**RE: Isburg Residence
6316 Tesuque Dr. NW
Grading and Drainage Plan
Engineers Stamp Date 4/29/2020 (E10D077)**

Based upon the information provided in your submittal received 4/27/2020, this plan cannot be approved for Grading Permit until the following comments are addressed:

GRADING AND DRAINAGE PLAN

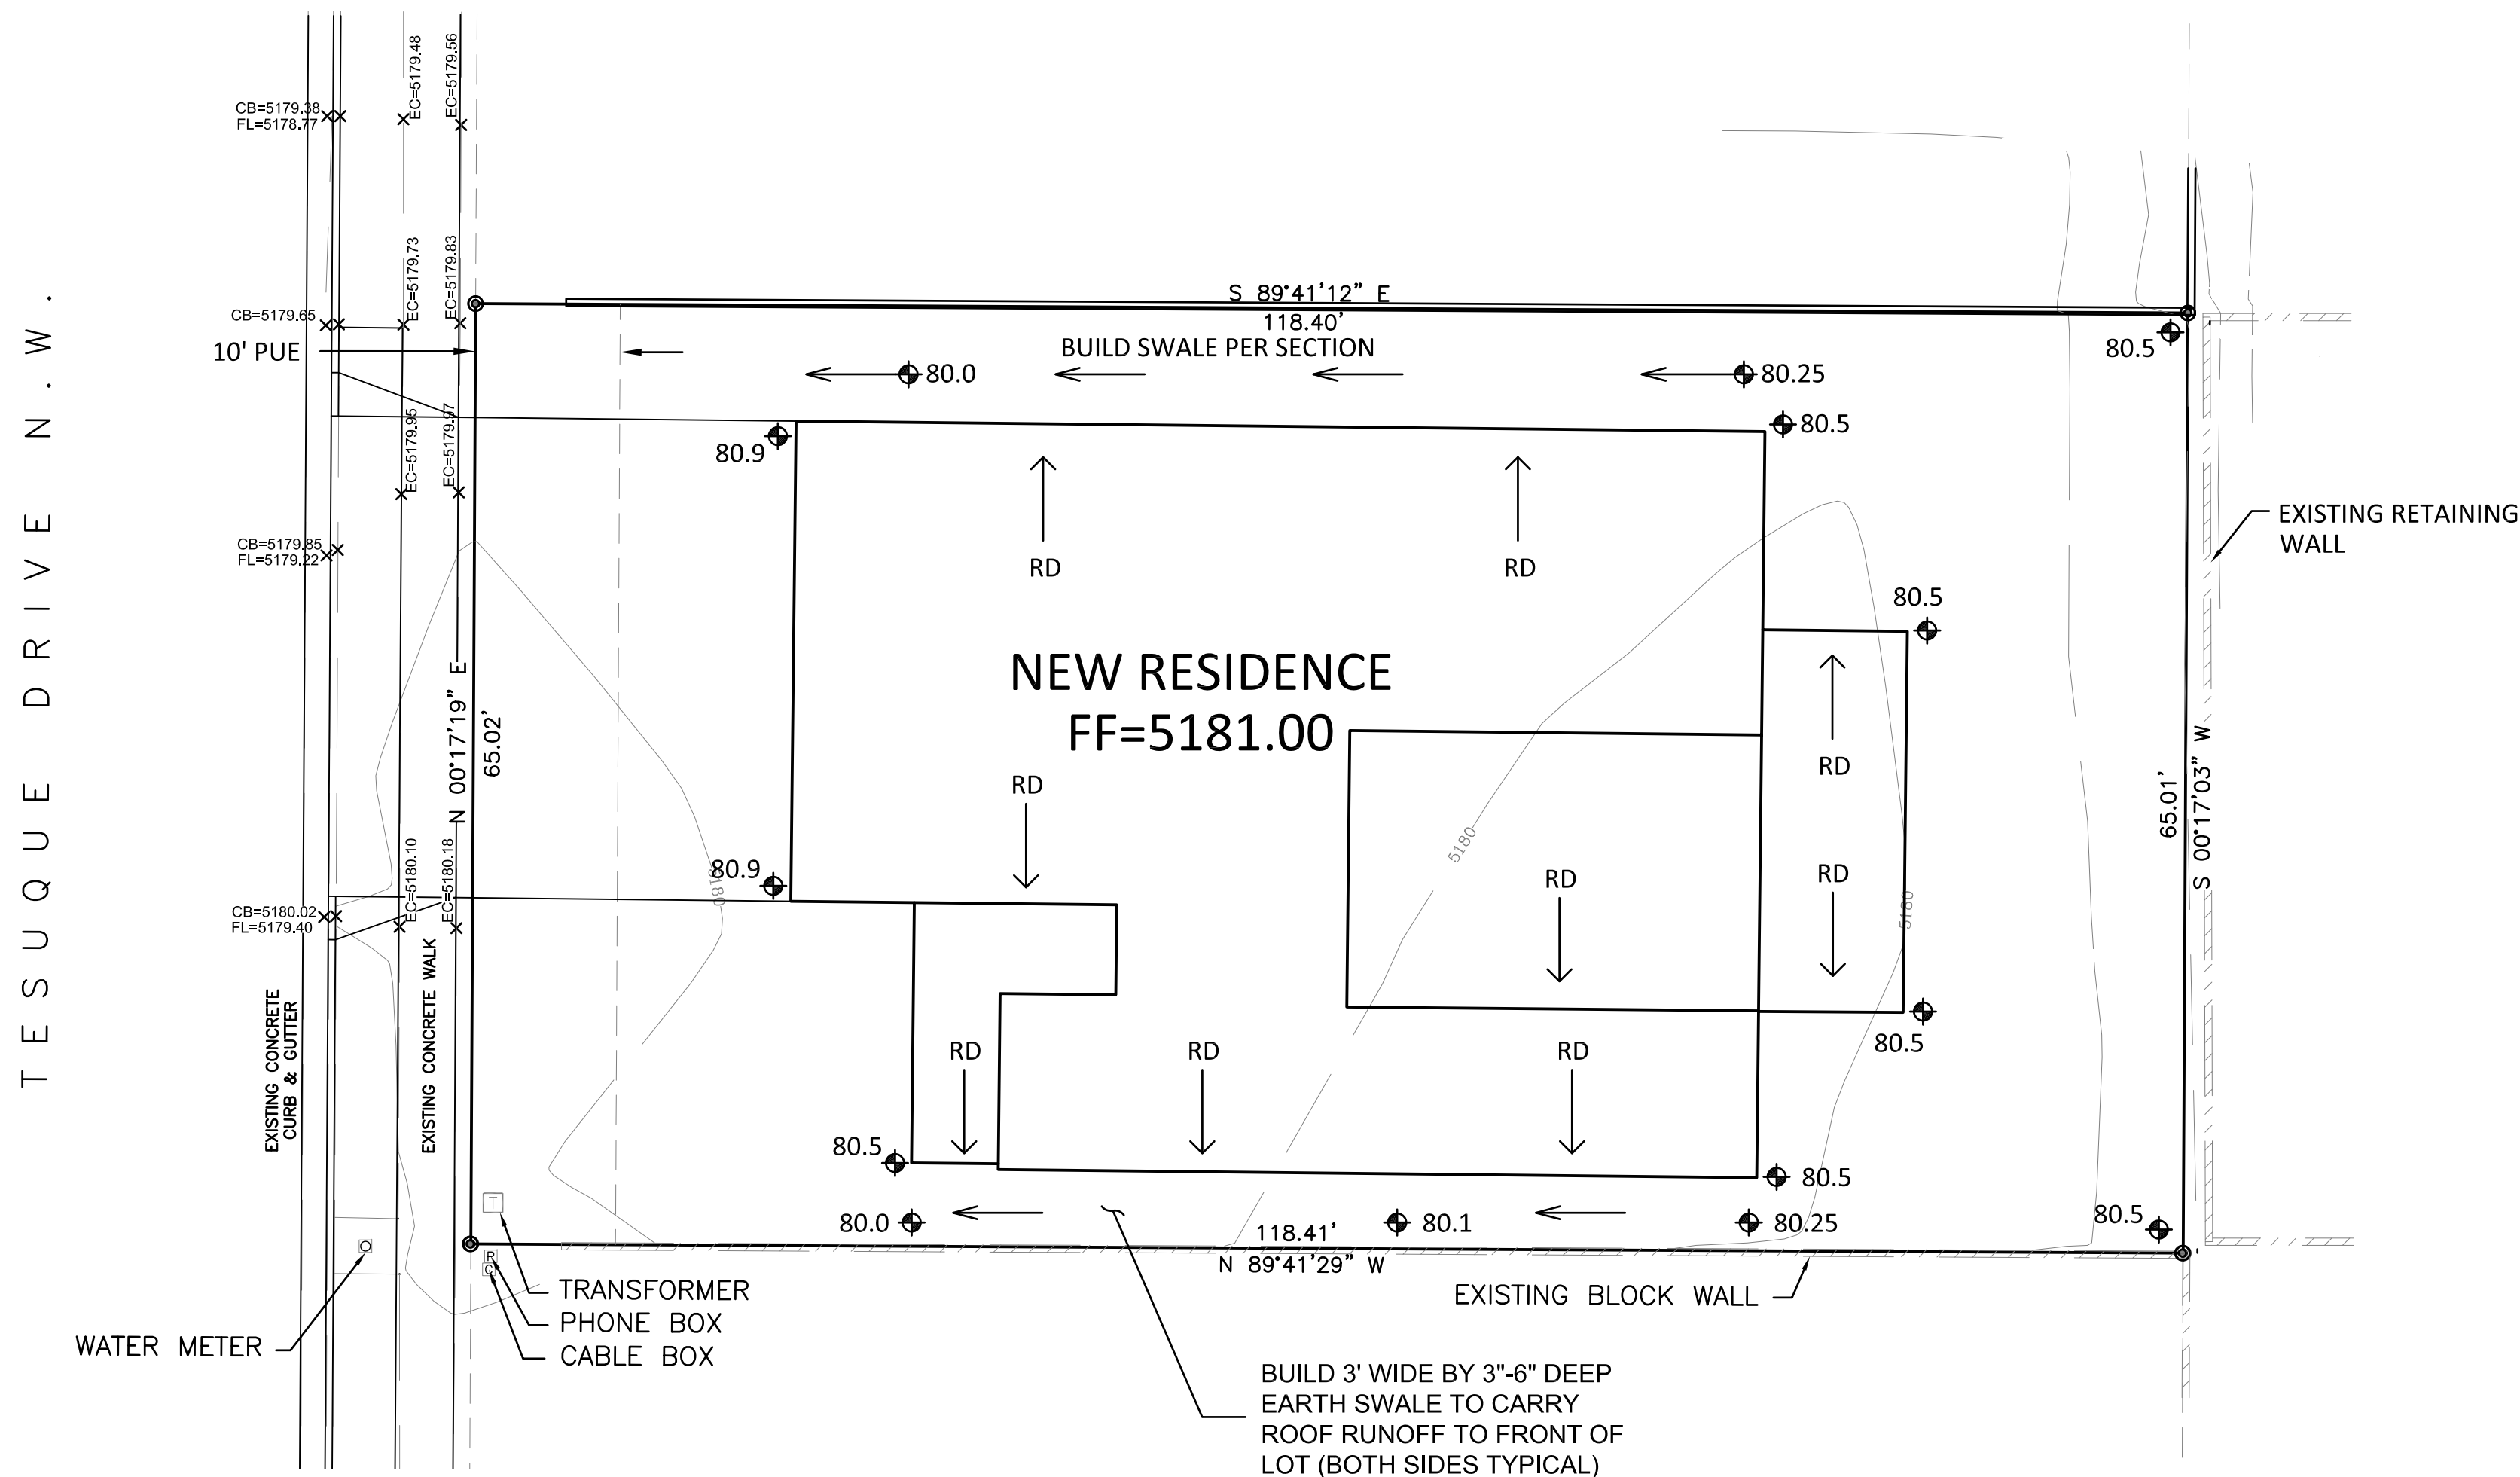
- Grade the entire rear yard elevation to 80.5.
- Provide profiles for the swales, showing gravel as the base.
